Proposed Balcony at 5 The Old Slipway, River Rd, Arundel

DRAWING
Second Floor Plan + Elevations
as Proposed

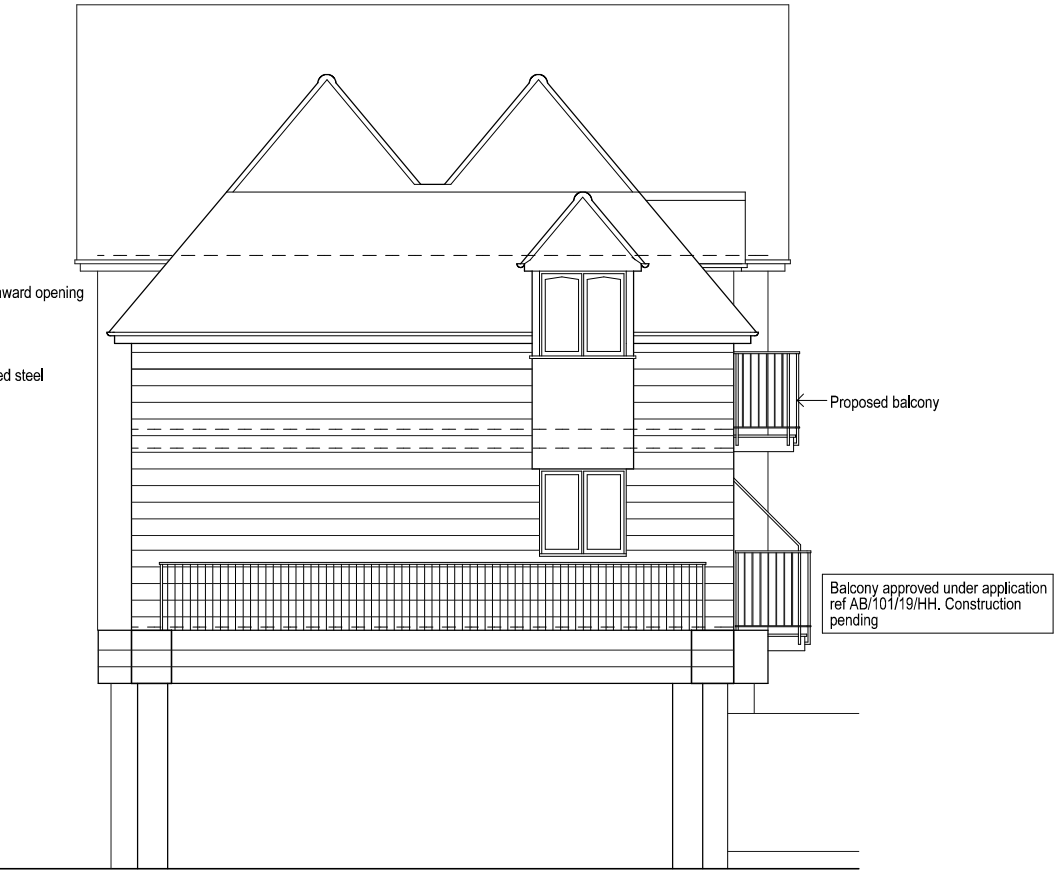
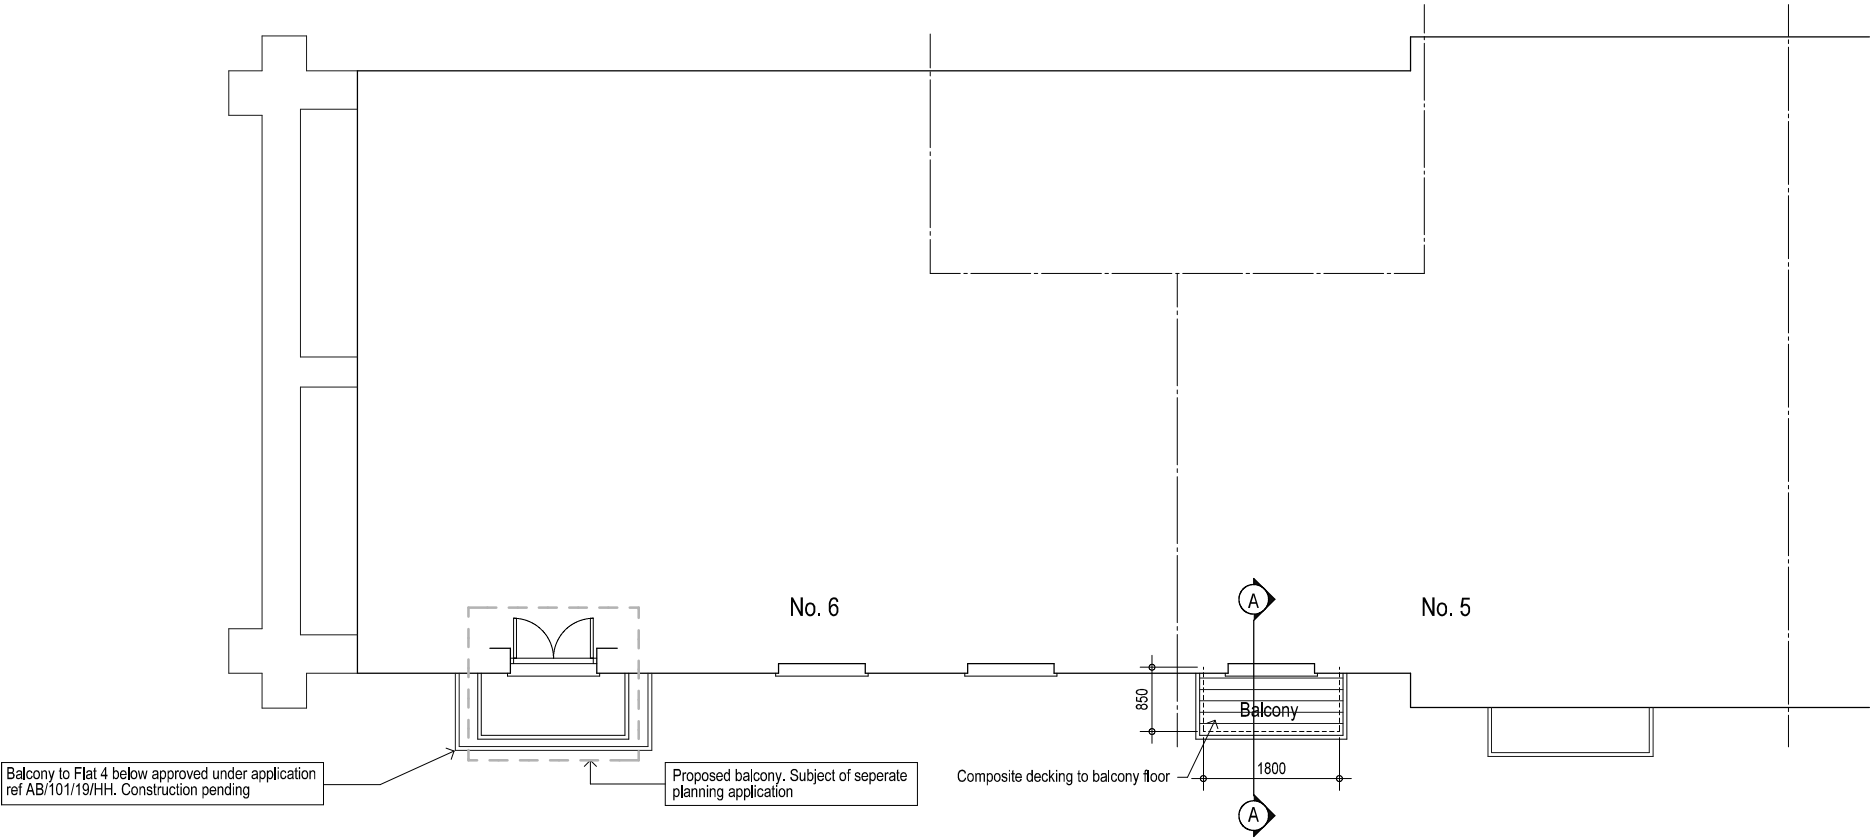
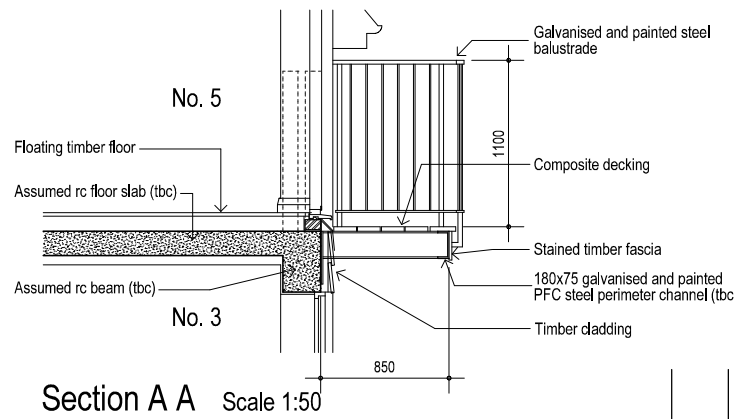
1. Loss of Privacy. This balcony will be directly above our terrace, on the second floor. This would significantly inhibit the enjoyment of our terrace by directly overlooking us. Although there is a small element of overlooking from the window that is there currently, by increasing the size and opening together with the physical structure of the steel balcony, the issue for being overlooked is greatly increased. There is a huge difference between someone looking out of a window and someone physically being on a balcony immediately above our terrace.

2. Detrimental effect upon the Character and Appearance of the Building from my terrace and the river. This elevation is clearly visible from my terrace and the river and by removing the existing window and a portion of the wall below cill level, installing inward opening French doors, and adding a steel balcony, it would detract from the character and appearance of the building and that of the Arundel Conservation area. It would also be overbearing having a steel structure at that height.

3. A previous application for a Juliet balcony was rejected and one reason was that it would create an unbalanced appearance on that elevation. In the Design and Access Statement it states that a future matching application for flat Number 6 counters this. I disagree and feel that two changes such as this will only serve to multiply the detracting from the character and appearance of the building. Two such
